October 4, 2016

RE: **Matthew Drive Storage**  
**3309 Matthew Dr. NW**  
**Grading and Drainage Plan**  
**Engineers Stamp Date 9/28/16 (H16D147)**

The purpose of this letter is to accompany the attached grading plan. The plan has been revised to address your emailed comments dated 9/28/16. We have included your comments and responded as to how we have addressed your comments

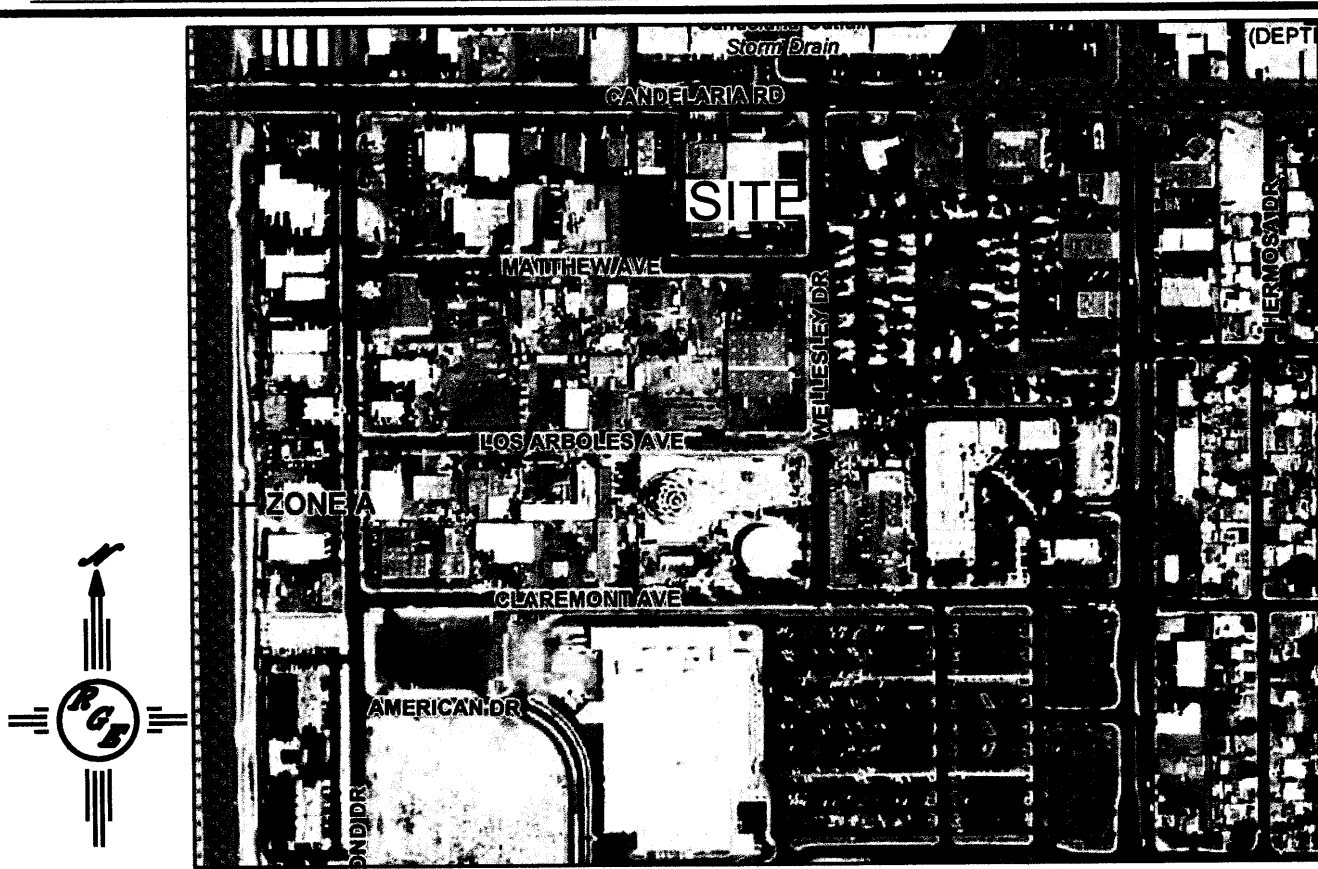
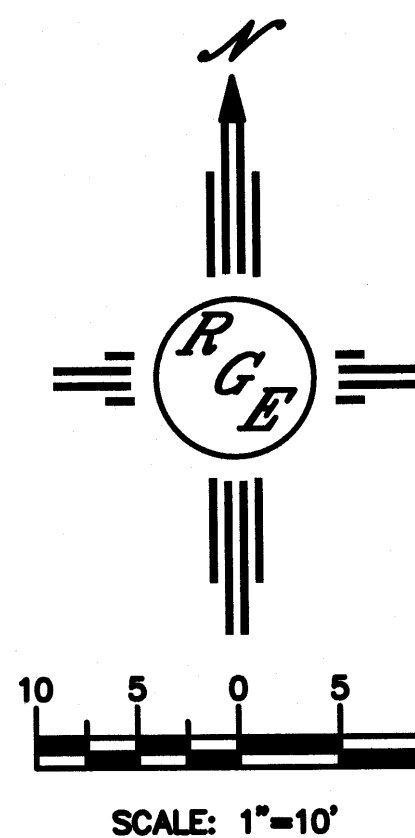
- Enlarge the drainage calcs or provide on a separate sheet with the proper font size. Once submitted the calculations will be checked.  
**We have increased scale of the calculations**

- Provide spot elevations outside the new buildings.  
**We have added spots**
- Statement on sidewalk culvert, add extend passed property line 1 foot.

**We have added note**
- Are the landscaping areas new? Is there a curb at the edge of pavement? Is the entire site paved?  
**The existing site is entirely compacted base course. We are not proposing pavement.**

- Provide a note in the SO-19 notes stating, to contact Jason Rodriguez at 235-8016 for the sidewalk culvert inspection before and after pouring the concrete.

**We have added Jason's contact information and instructions**
- Provide a notes stating, The curb stone for the sidewalk culvert must be removed from joint to joint, no cutting.

**We have added this note**
